JR PLANNING
VELOCITY POINT
WREAKES LANE
DRONFIELD
S18 1PN

**LETTER TO ACCOMPANY AMENDED PLANS FOR APPLICATION 2025/0153 AT HIRST
COTTAGE, BILLINGLEY**

Following recent discussions and a review of the consultation responses, I am pleased to submit amended drawing numbers reference 2025/114 01 Rev A and 2025/114 02 Rev A and. The amended plans address the issues that have arisen during the application to date, and should allow the application to proceed to a positive outcome. The key Green Belt and Heritage issues are addressed below.

Drawing Title.
**SITE & LOCATION
PLAN AS PROPOSED**

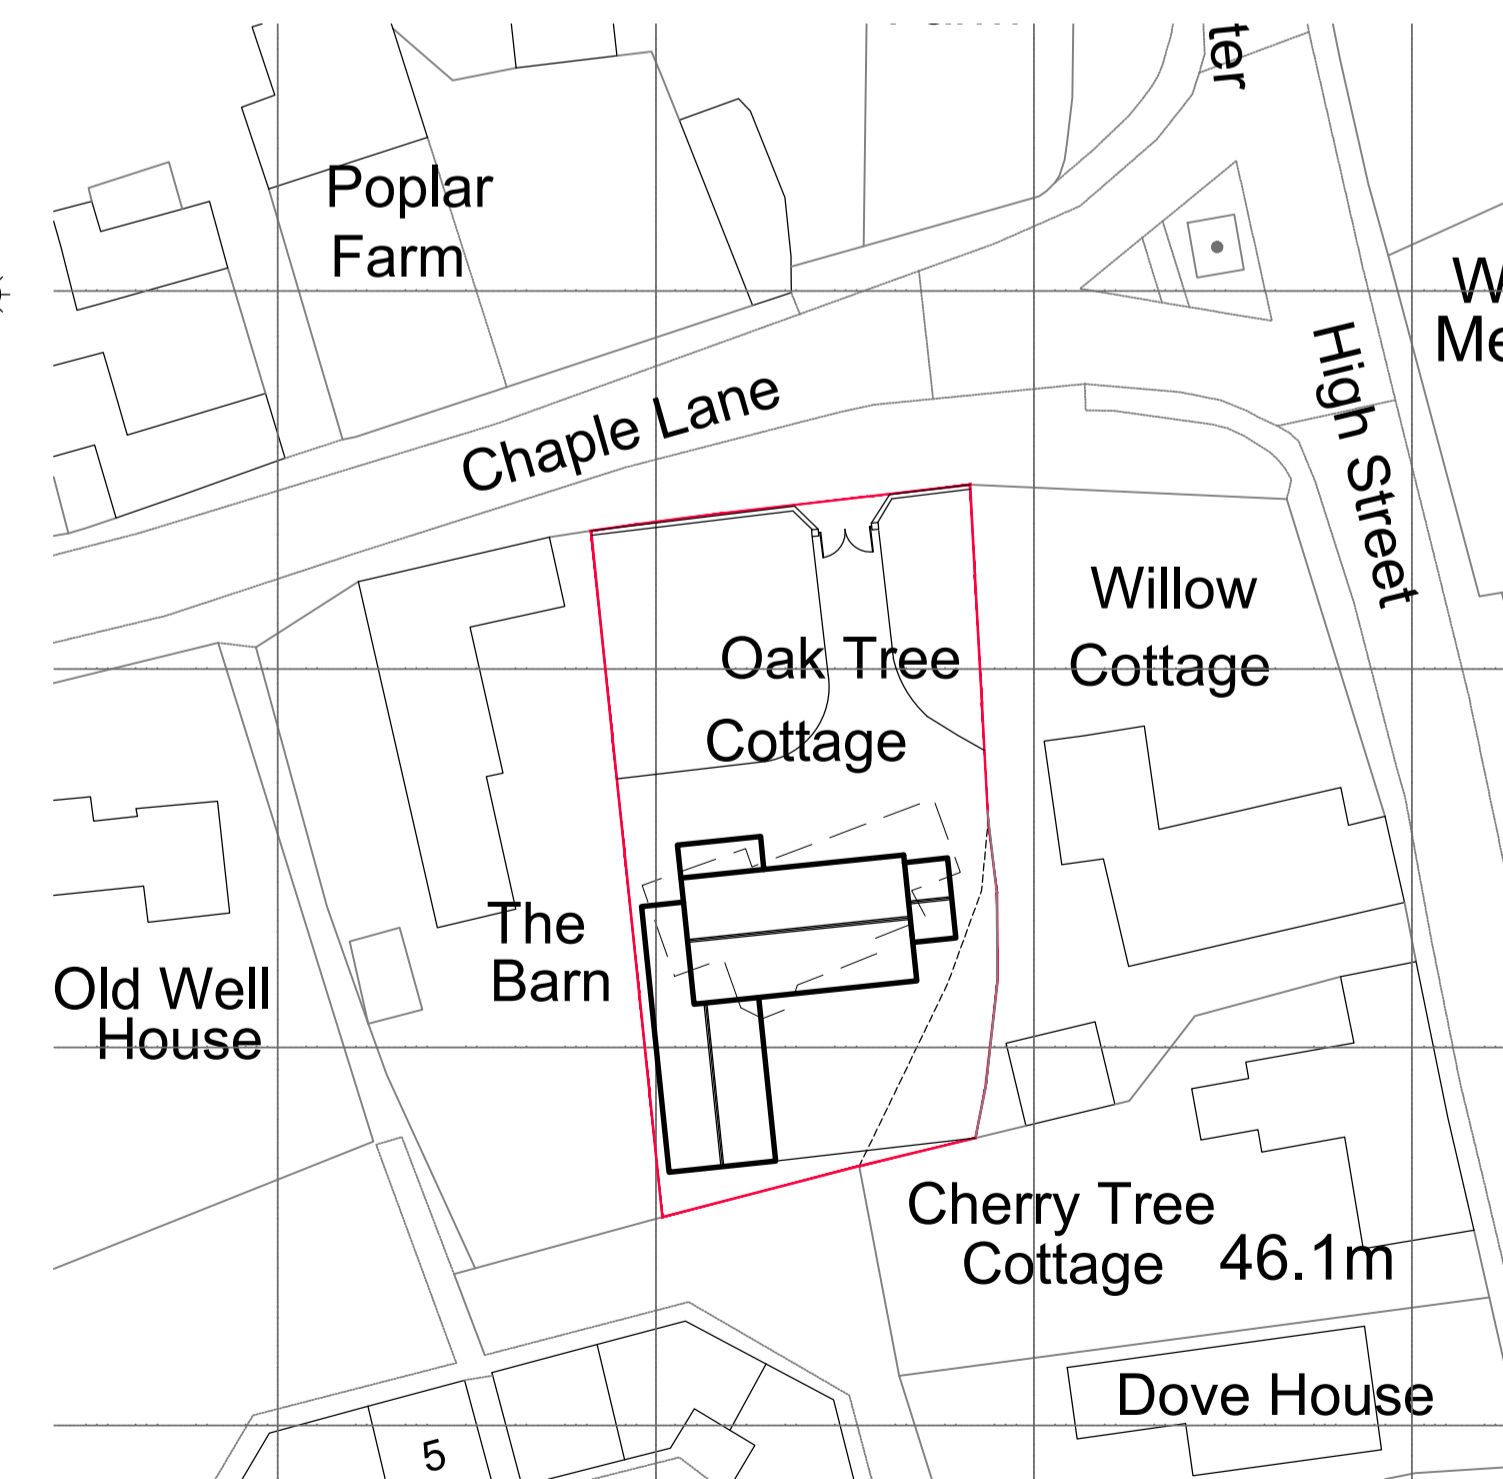
The scale, position and appearance of the proposed dwelling as amended now fully reflect and respect the grain and appearance of the conservation area. The historic relationship between the building and Chapel Lane is maintained, with the generous set back and large front garden space retained. No trees are impacted by the proposal.

Drawing Title.
PLANS, ELEVATIONS & SECTIONS AS PROPOSED

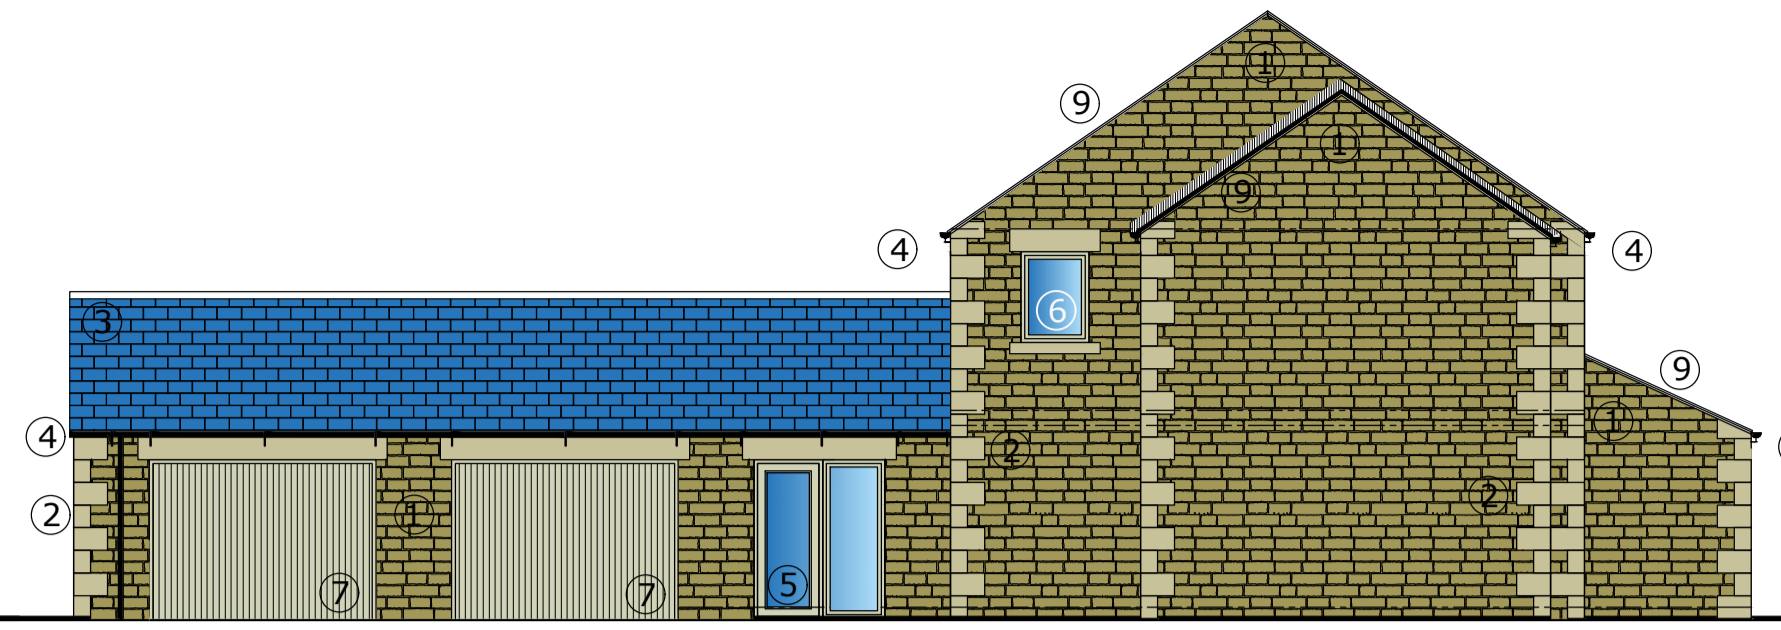
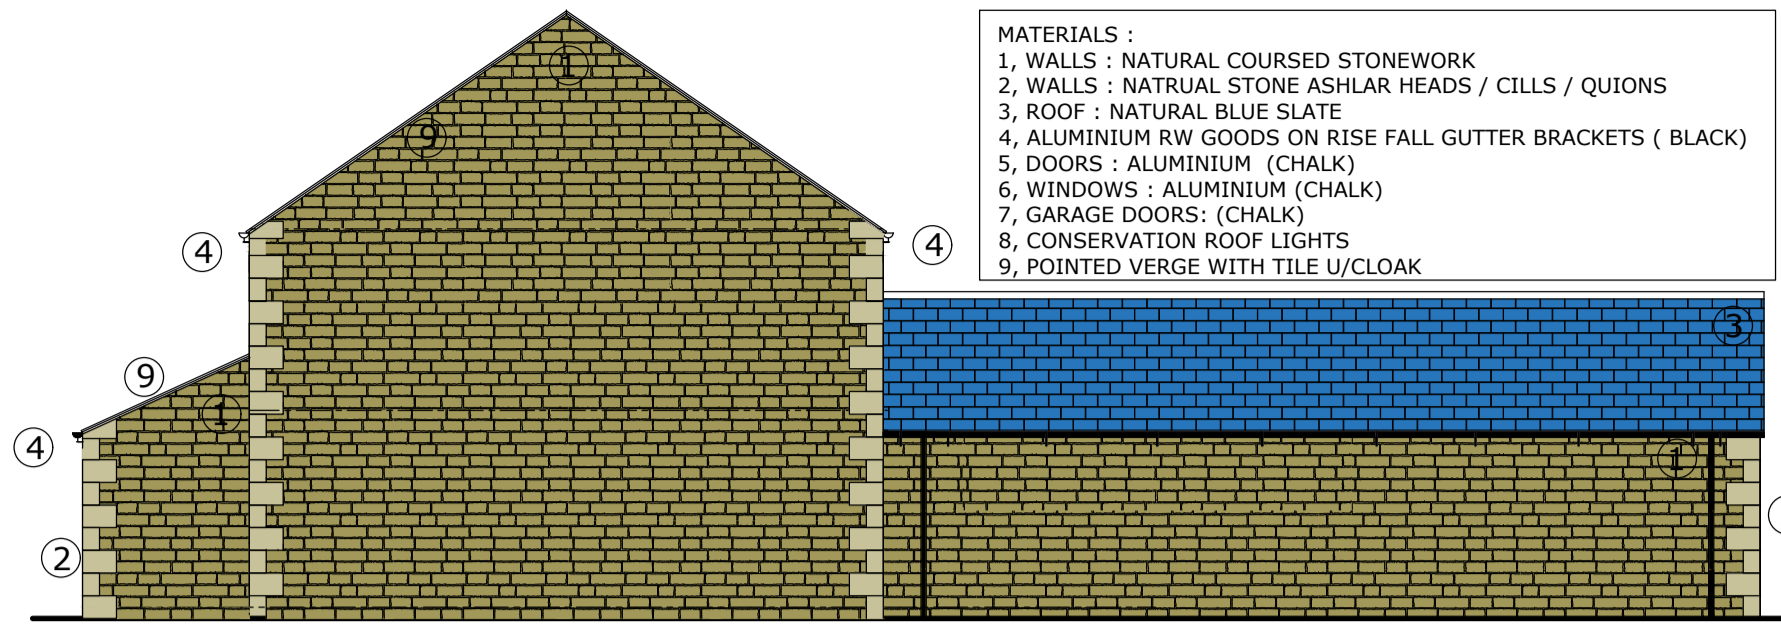
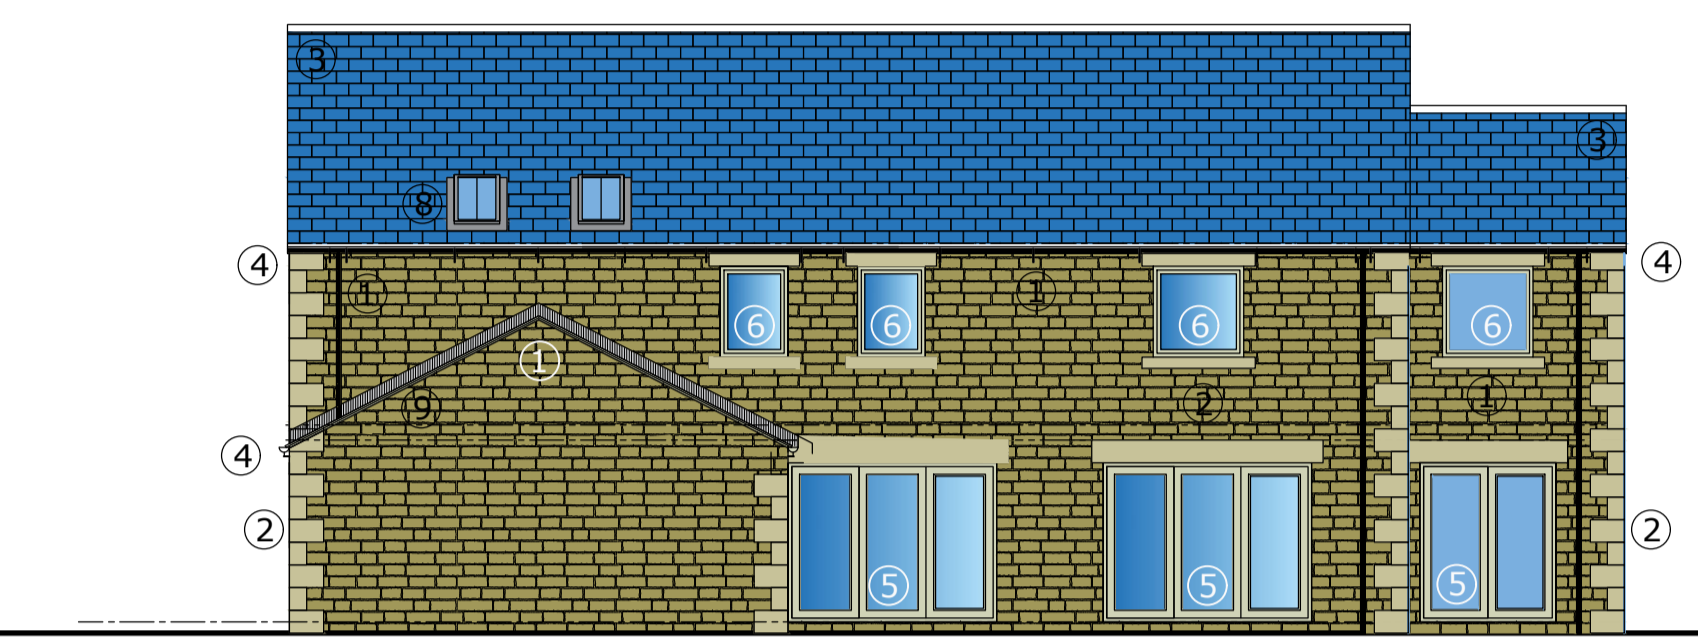
- Front gable omitted, restoring the vernacular appearance, form and scale of the front elevation.
- The garage projection reduced back to a double garage, with the room above and dormer windows omitted.
- Appropriate detailing added to the fenestration (quoins, windows surrounds etc.).
- Position and footprint very similar to the approved extension scheme.
